From: Mark Jones
Sent: 04 December 2017 19:10
To: Planning
Cc: Daniel Vick
Subject: FW: 19 A'becket's Avenue

Dan I have WFS this report I asked Chris to confirm cladding colour and he sent the attached revised plan

PROPOSED GARAGE DETAILS

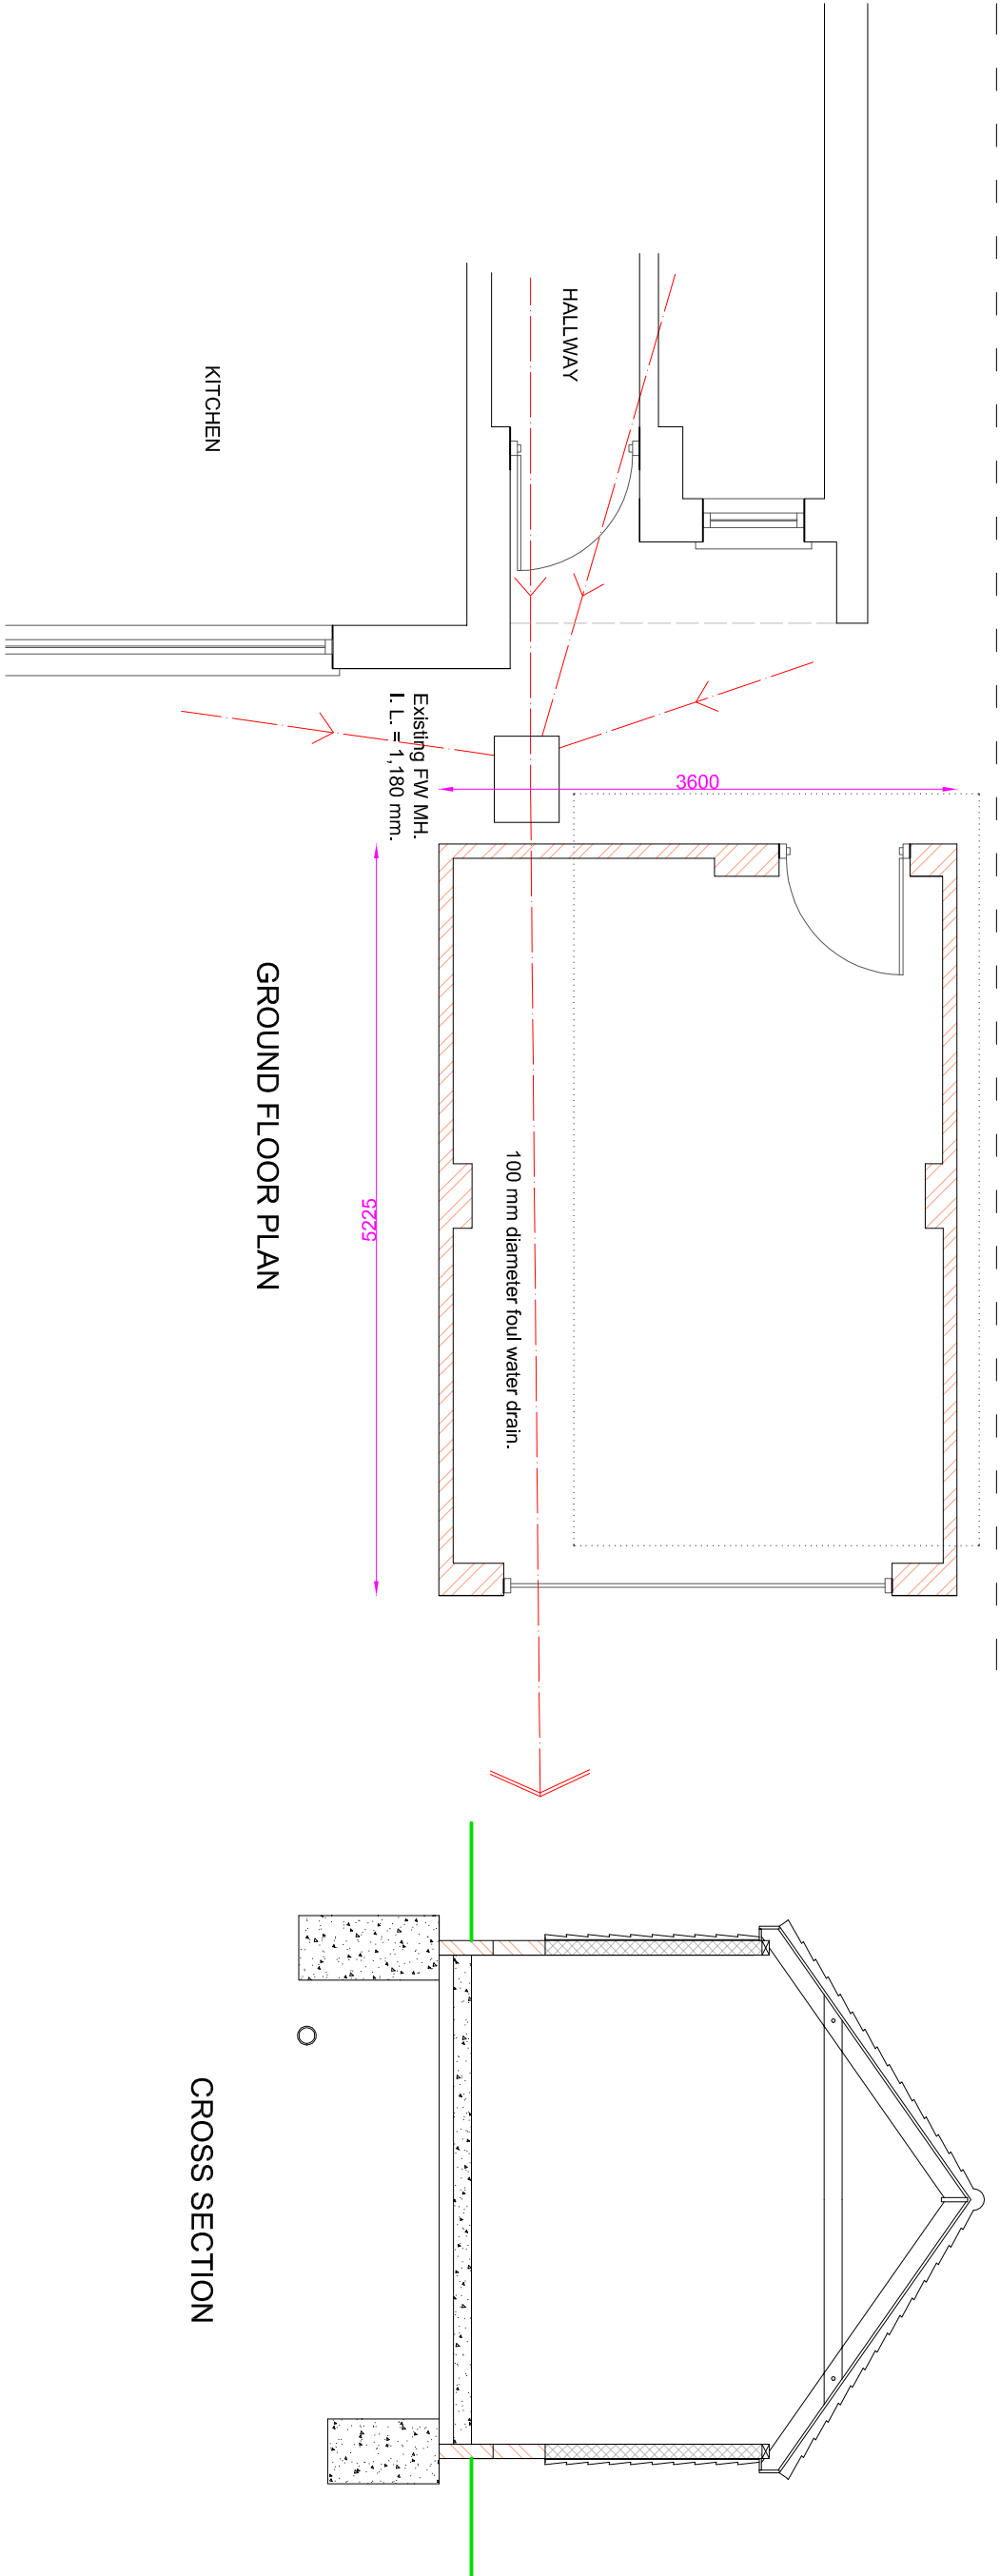
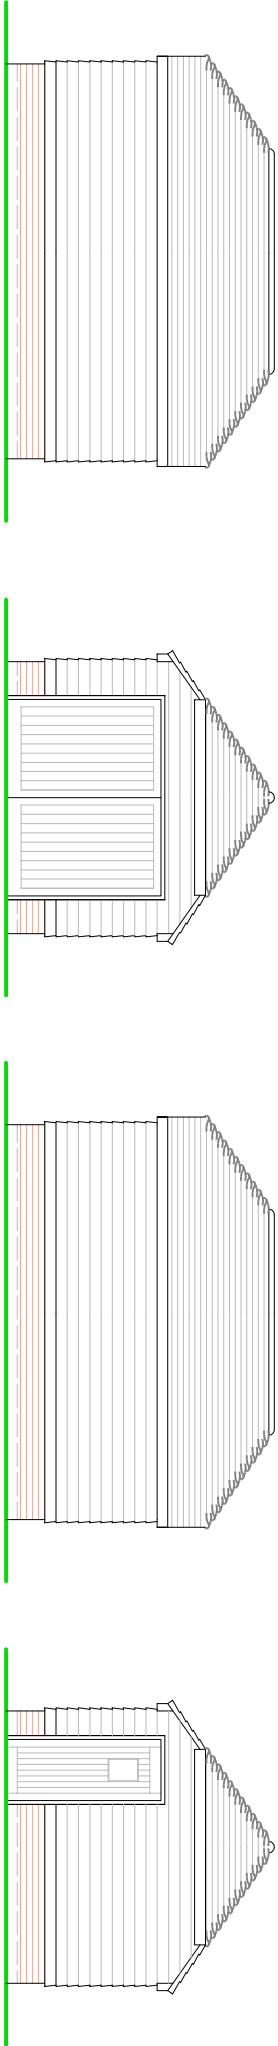
Can you let me know what colour the cladding on the proposed garage will be

To keep in with the style of the original and with the majority of others surrounding, the cladding will be either 'black' or 'charcoal grey'— revised detail attached. Please let me know if you have any issues with this.
